WELWYN HATFIELD COUNCIL – DEVELOPMENT CONTROL
DELEGATED REPORT

APPLICATION No:	N6/2010/1275/FP
------------------------	------------------------

The application seeks planning permission for the replacement of windows on stairwell and panels, formation of three ramps on footpath and dropped curb on Block one of Woodside House.

Drawing Title: block 1 - proposed ground floor

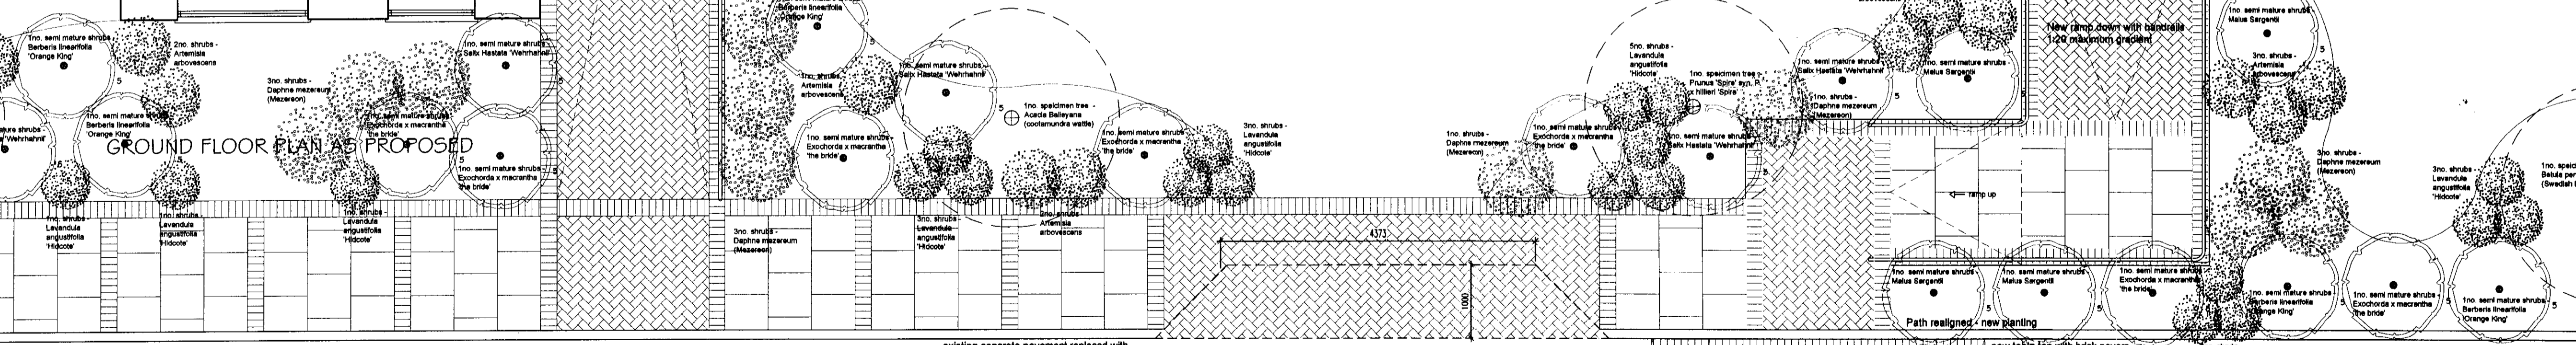
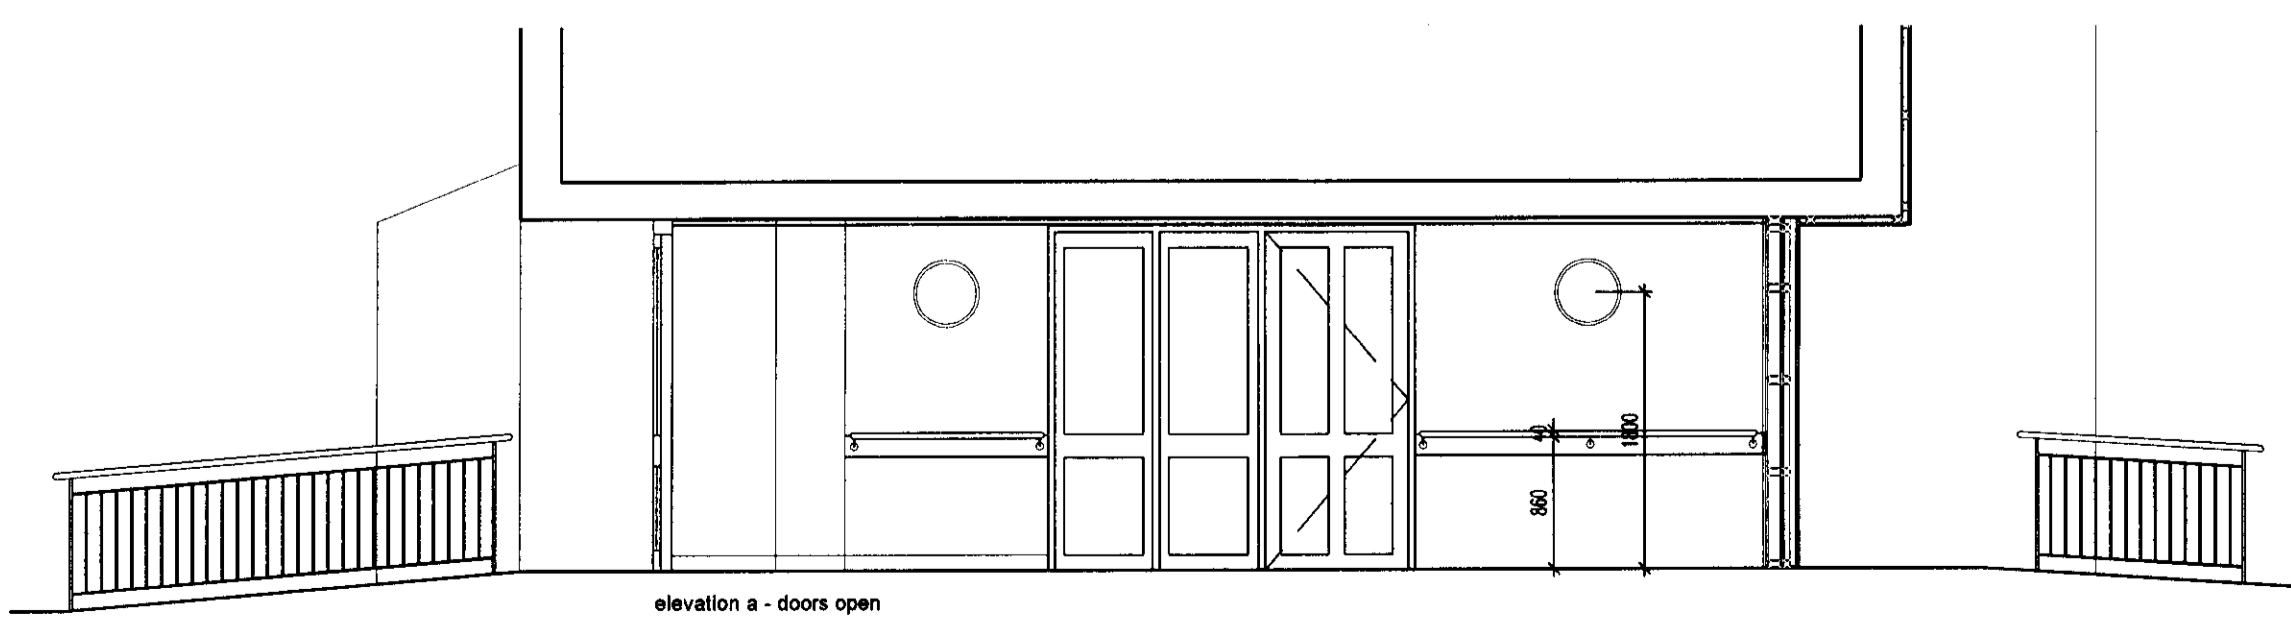
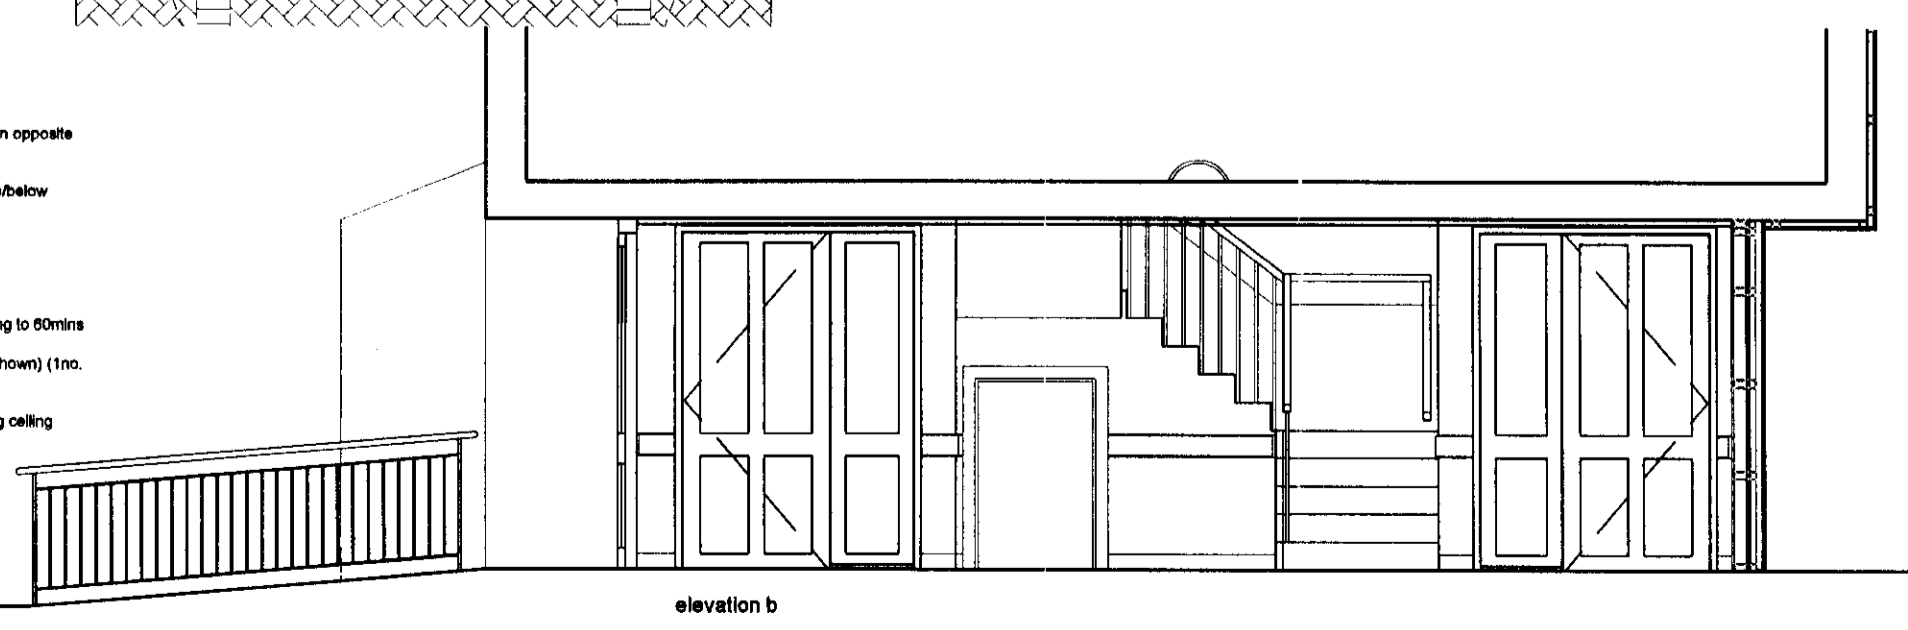
Alterations would be made to the existing ramped accesses into the building and the paths to the entrance would be paved with block paving. The existing concrete pavement would be replaced with Marshalls paving slabs. It is considered that these proposed alterations would help improve access for people with a disability and improve the overall character and appearance of the building and site.
